# CITY OF ALBUQUERQUE

April 23, 2009

**Re: North I-25 Corporate Center Conceptual Grading and Drainage Plan  
Engineer's Stamp not provided, (B18/D01C)**

# SHEET #3

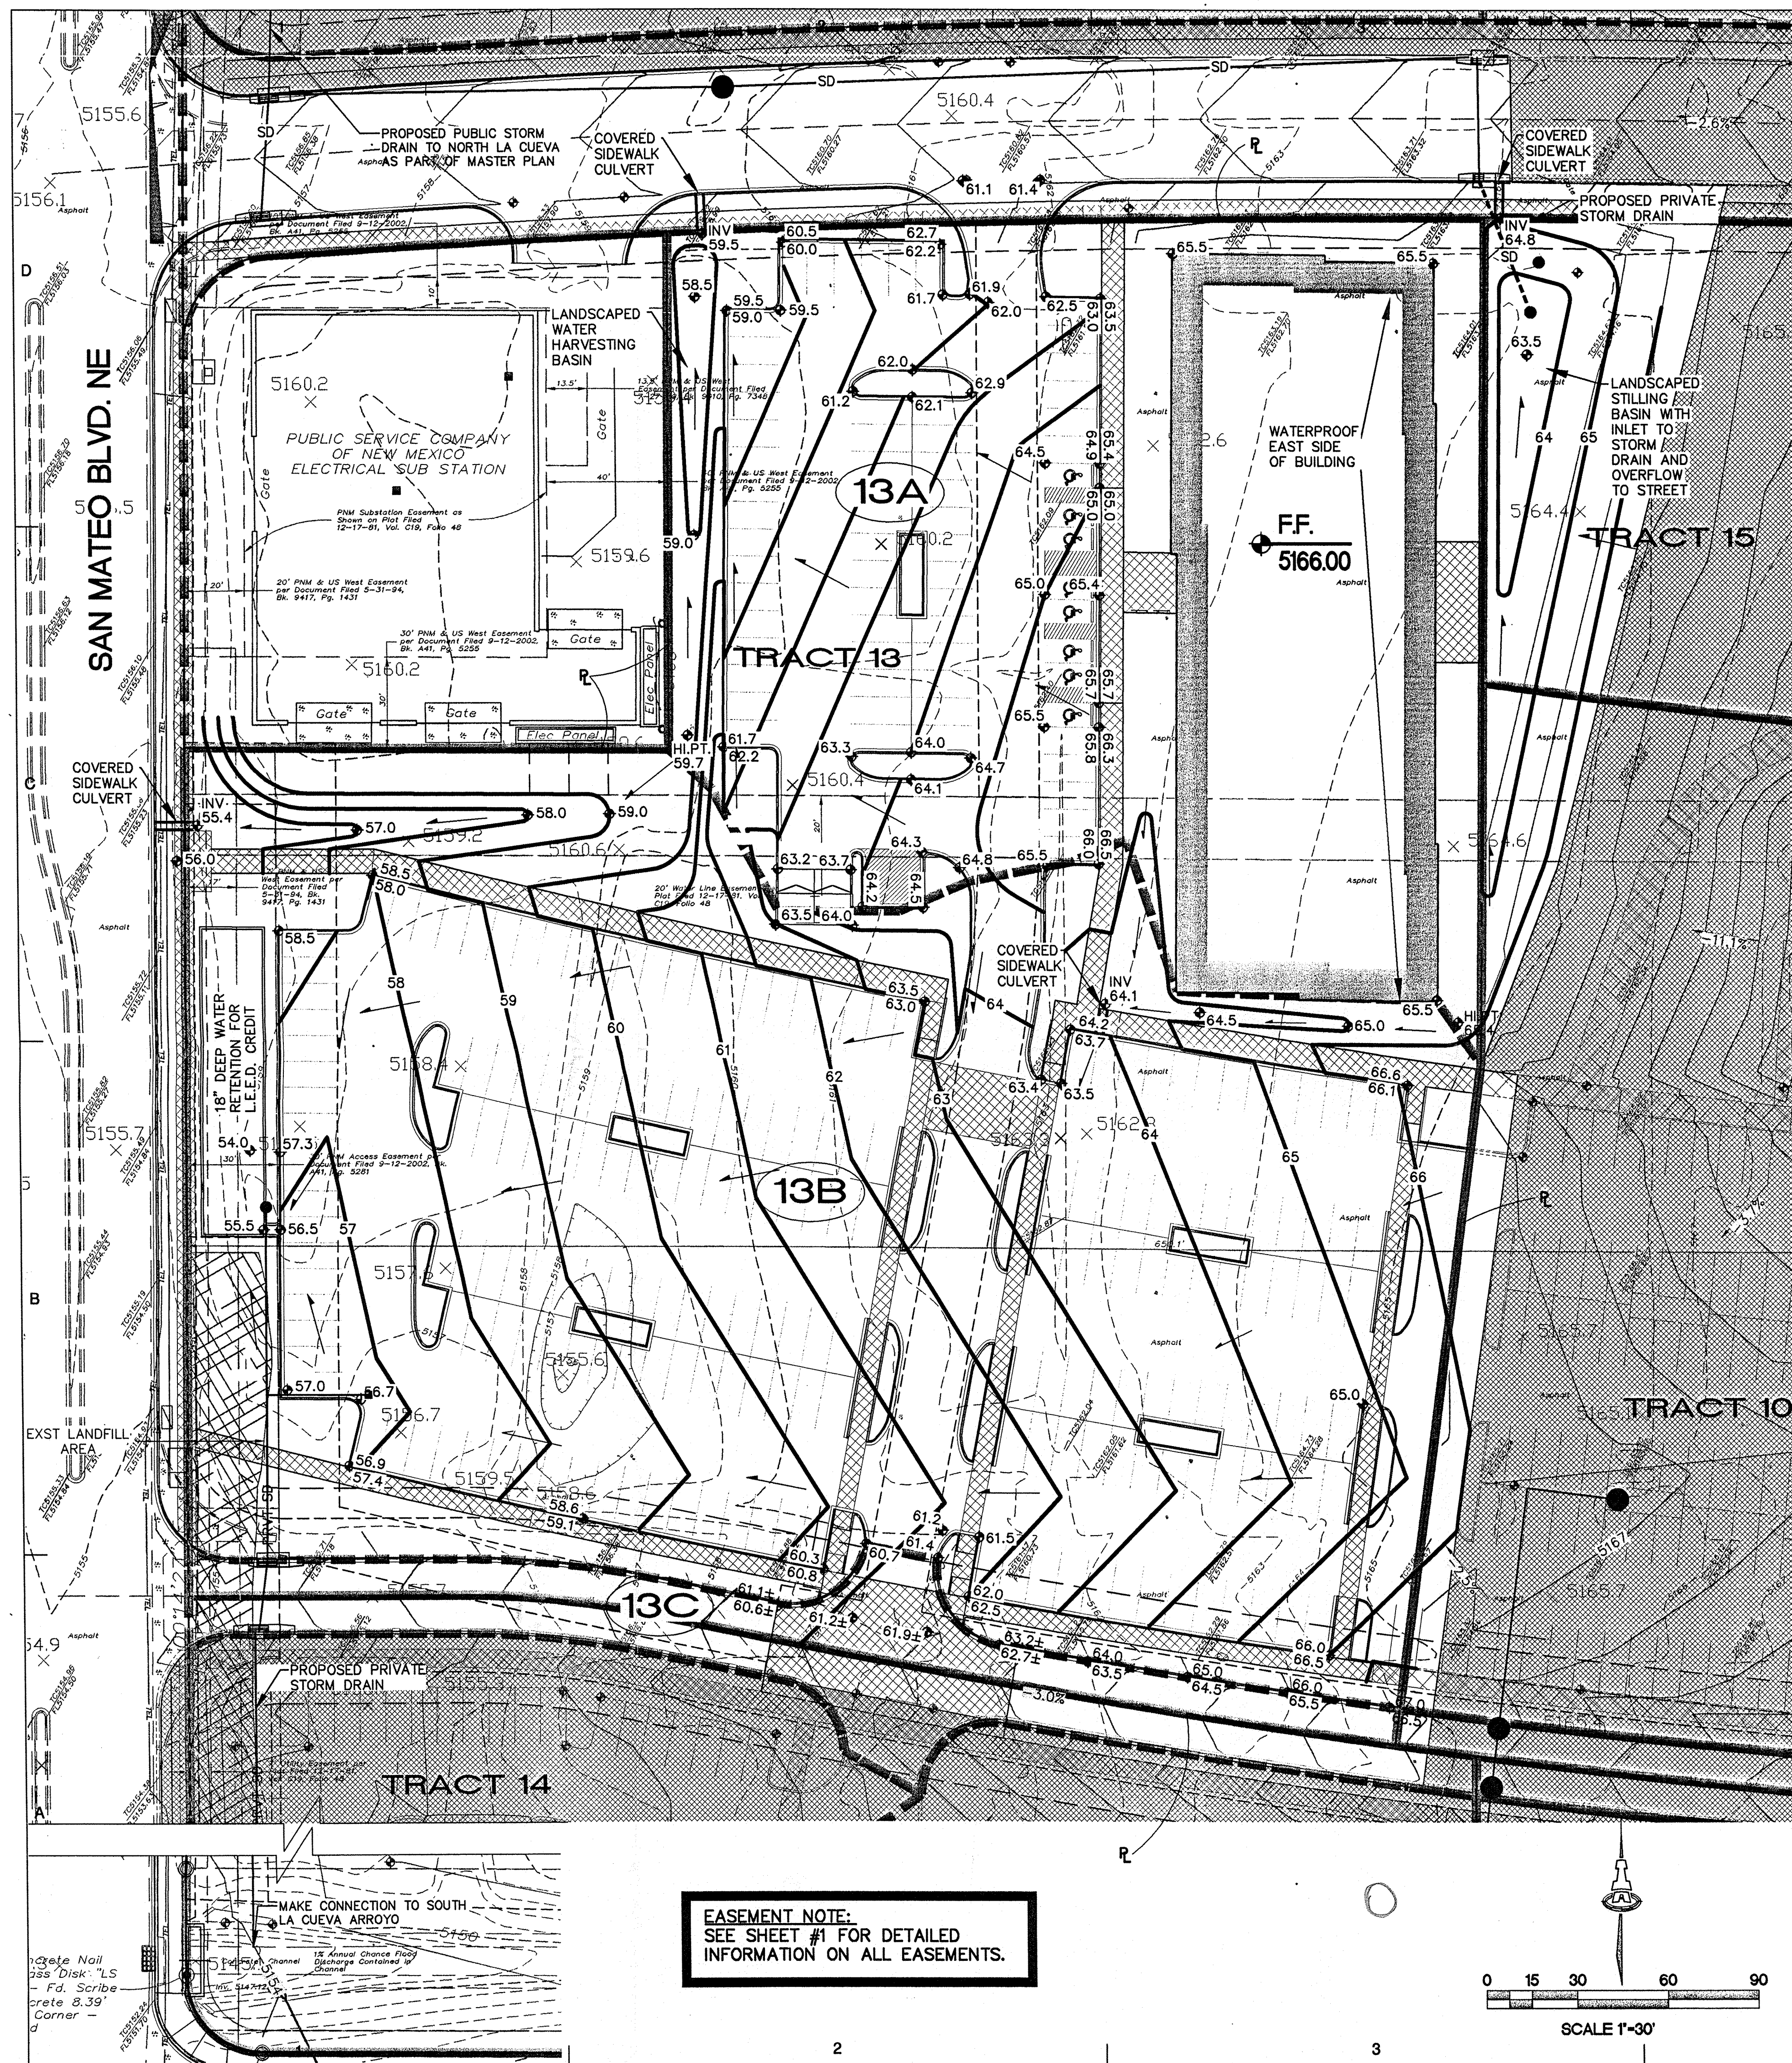
- Please provide a basin delineation map. It is likely that it will be altered as development plans are firmed up for each phase but I need something to start from.
- Please provide pipe sizes based on the above basins. Provide enough design to determine available capacity, necessary inverts, conflicts with other existing and proposed utilities, etc. Why is the storm drain in the northwest corner proposed to be public?
- What offsite (existing and future proposed) runoff enters the site? Please provide appropriate excerpts from any existing reports (both runoff tables and upstream basin maps) to support your proposal.
- Please show proposed lot lines and easements (public and private) and dimension.
- This report should be stamped, signed and dated. Keep in mind that this will be the blueprint for all development within this property.
